Report of the Head of Planning and Development**HEAVY WOOLLEN PLANNING SUB-COMMITTEE****Date: 14-Apr-2021****Subject: Planning Application 2019/91239 Demolition of existing public house and erection of four dwellings The Shears, 201, Halifax Road, Hightown, Liversedge, WF15 6NR****APPLICANT**

TITLE
 PROPOSED ELEVATIONS - PLOTS 1 & 3

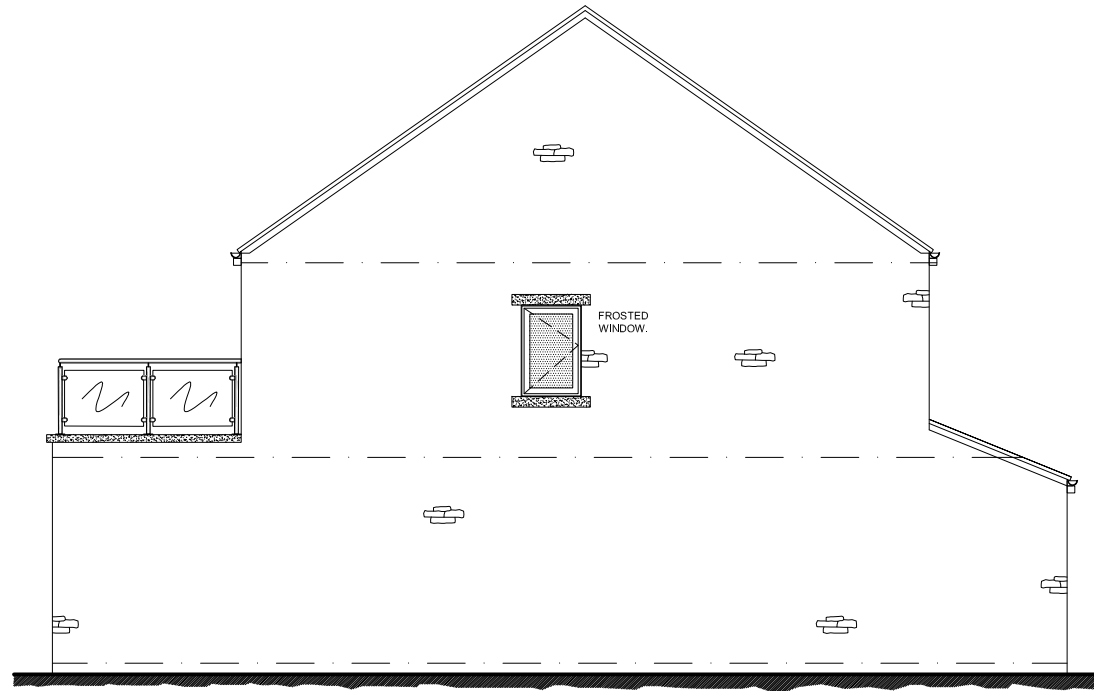
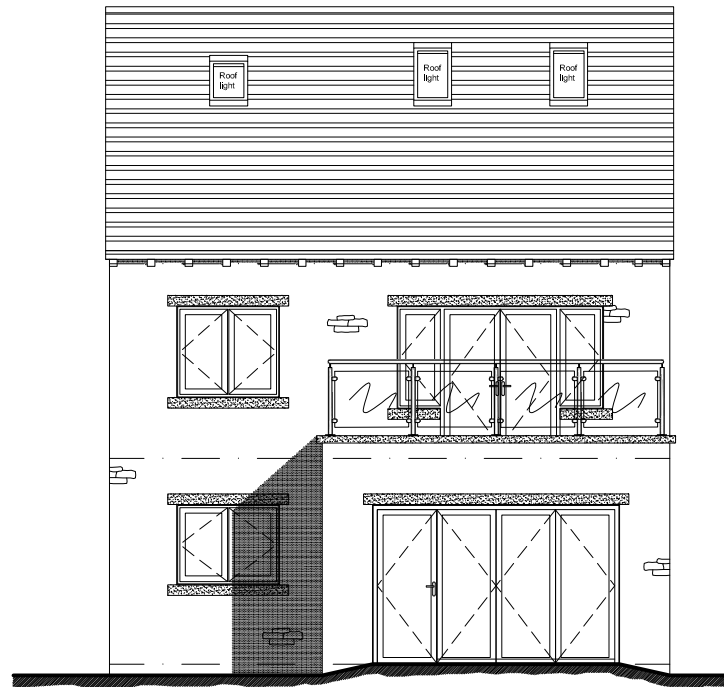
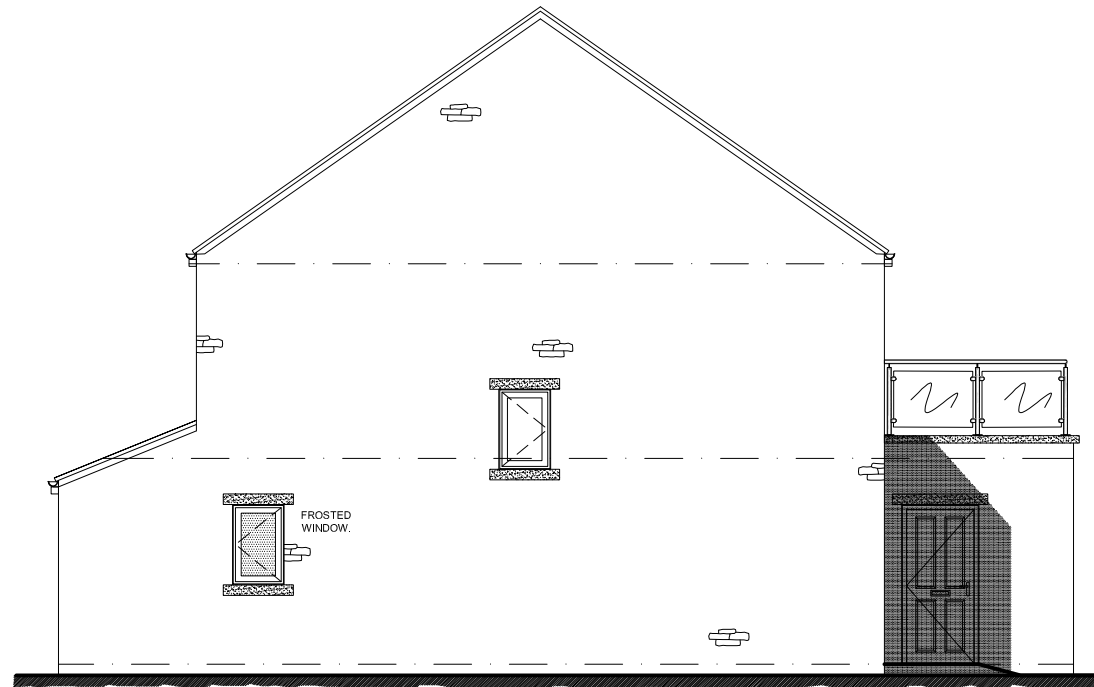
- 10.16 The proposed dwellings would be 2 ½ storeys in scale including attic accommodation with porches to the front and first floor balconies to the rear. roofs with eaves parallel to the street. Proposed materials of construction are artificial stone with concrete tile roof, with wood-effect upvc windows and doors and dark grey aluminium bi-fold doors.

- 10.18 With regards to the form of the development, front porches are not typical in the immediate vicinity, nor are first floor balconies.
- 10.19 The proposed materials of construction of the development are found within the immediate locality, generally on later developments that in Officers' opinion, have weakened the townscape. Natural stone walling and stone or slate roofing are more traditional and would better respect the local character of the area.

TITLE
PROPOSED STREET ELEVATION

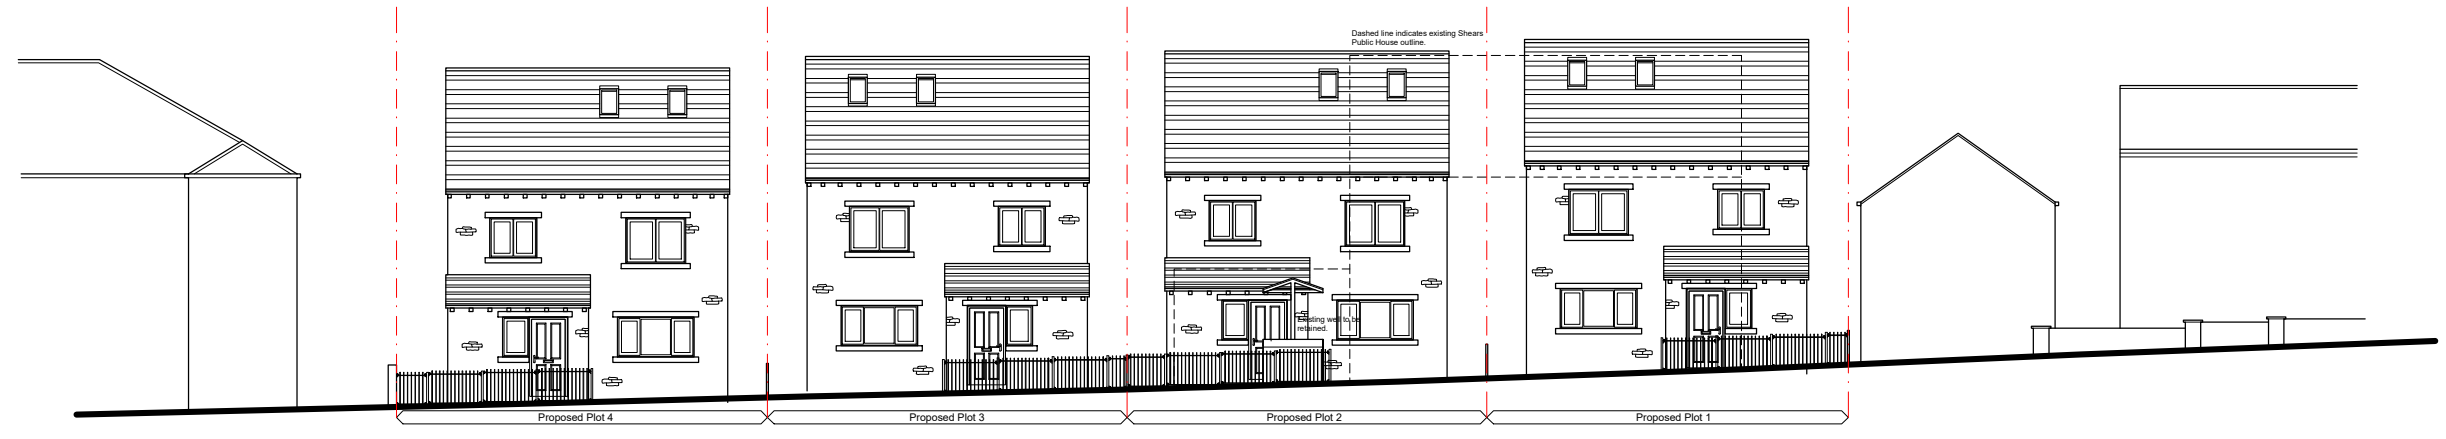
- 10.17 The proposed layout of the development is of particular concern to Officers as it would weaken the quality of the local townscape by replacing a building providing strong containment to views with a development set back from the road by approximately 8m, and dominated by parked vehicles. Whilst the townscape of Hightown is varied, short terraced rows and detached properties or semi-detached pairs in larger plots are more common. There does not appear to be a local precedent for development of this type.

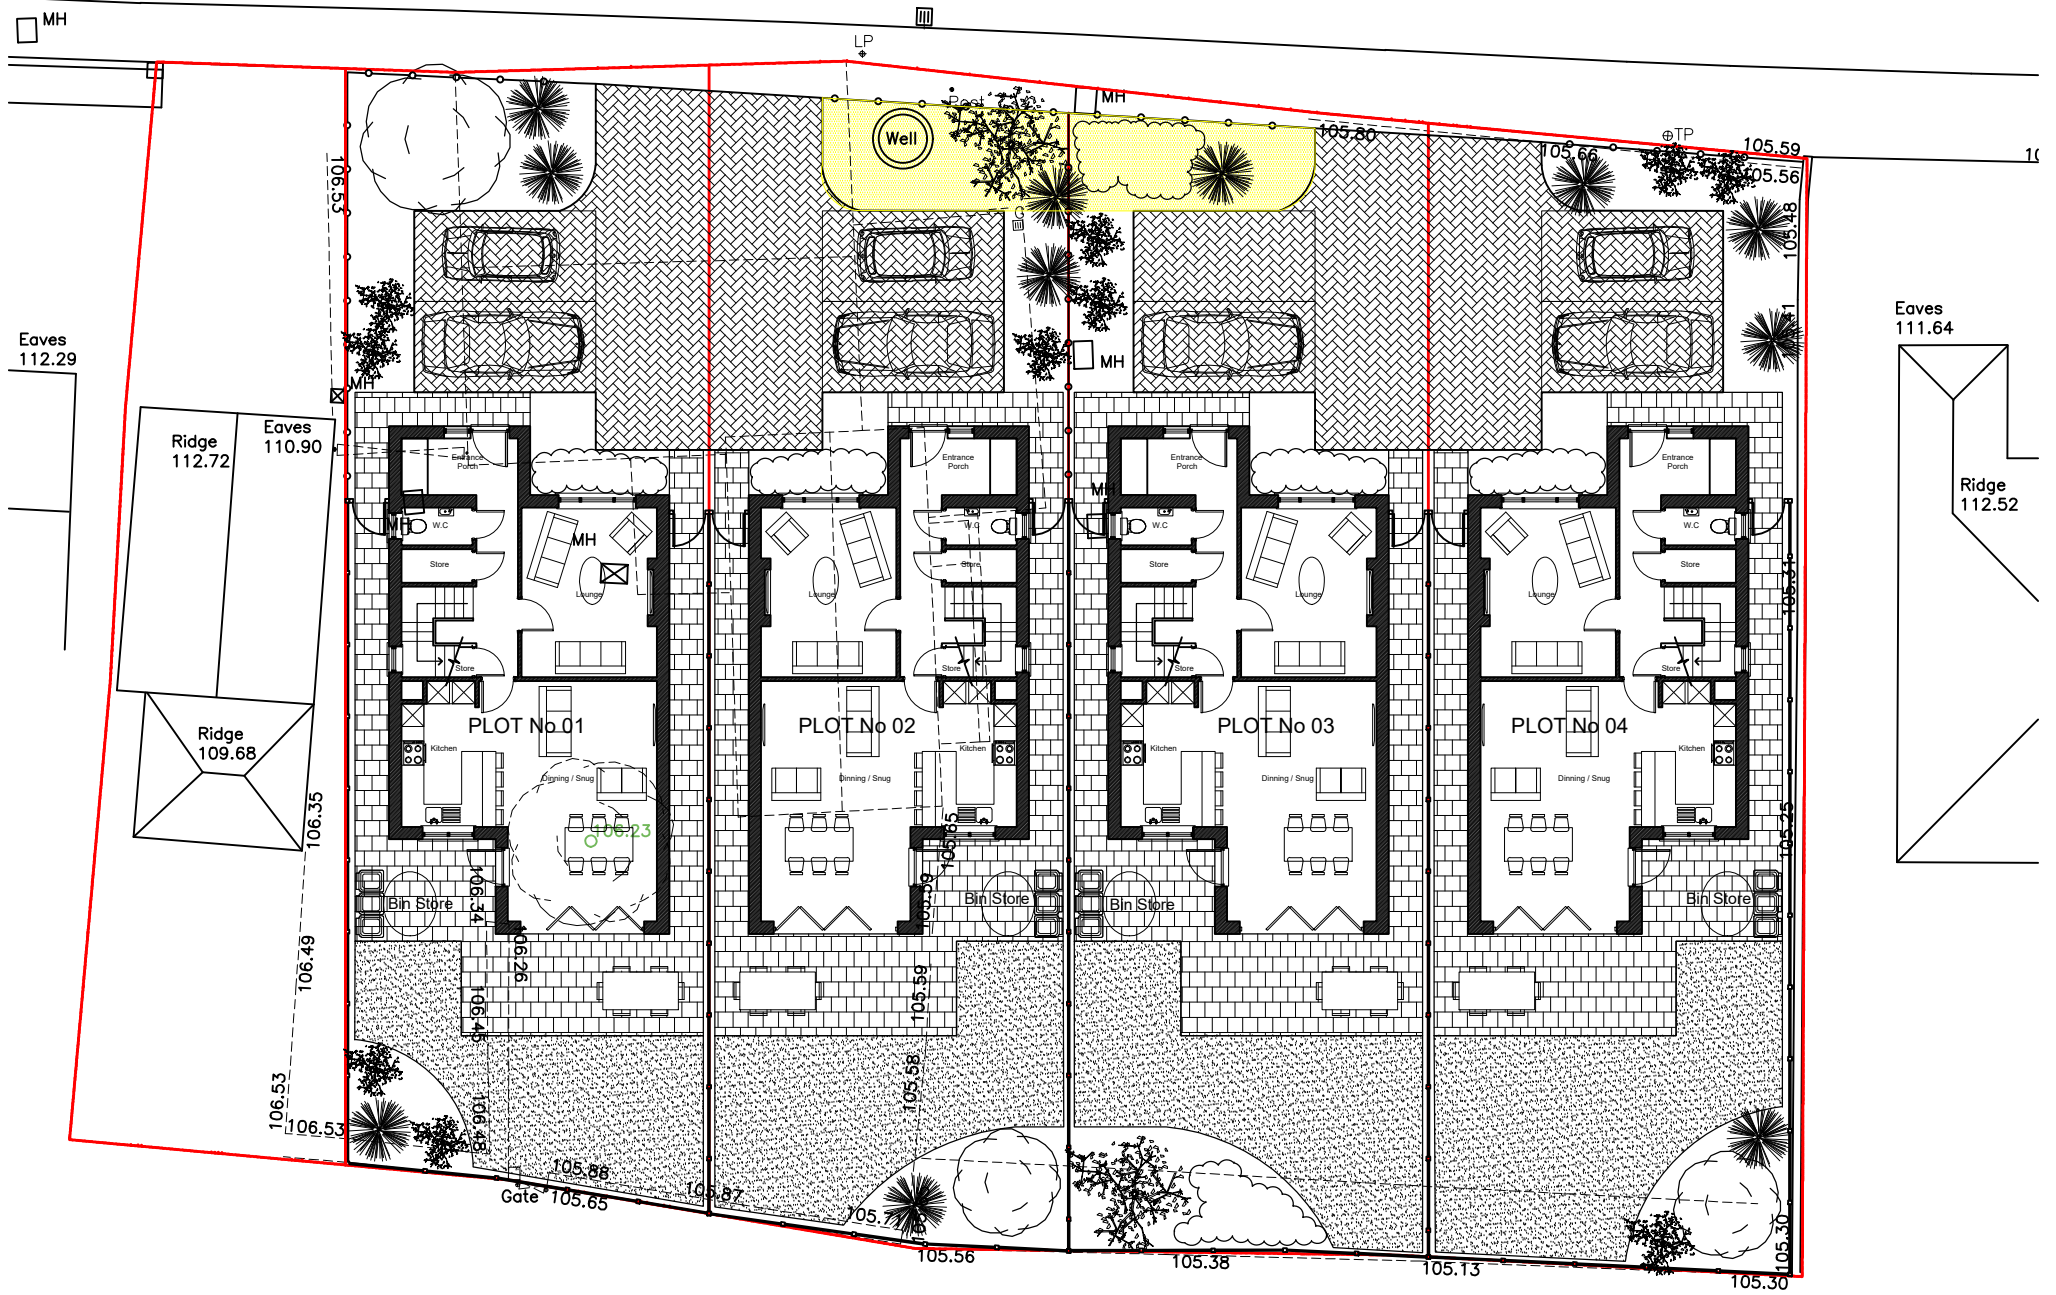
- 10.36 The application site is located on the southern side of the A649 Halifax Road. The proposed development would involve the demolition of the existing public house and the erection of four dwellings on the site. The originally submitted plans indicated the provision of separate driveways to serve each dwelling, providing internal turning and off street parking provision for two vehicles per dwelling.

- 10.37 Amendments were requested during the course of the application in order to secure widened points of access, bin collection points, and widening of the pavement to the site frontage. Negotiation also took place with the applicant to explore options for improving the design of the parking layout from a visual amenity perspective, whilst meeting the requirements of KC Highways DM.

- 10.38 Following receipt of amended plans, the proposals are considered acceptable from a highways safety perspective and would accord with the aims of Policies LP21 and LP22 of the KLP as well as the aims of the Highways Design Guide SPD.
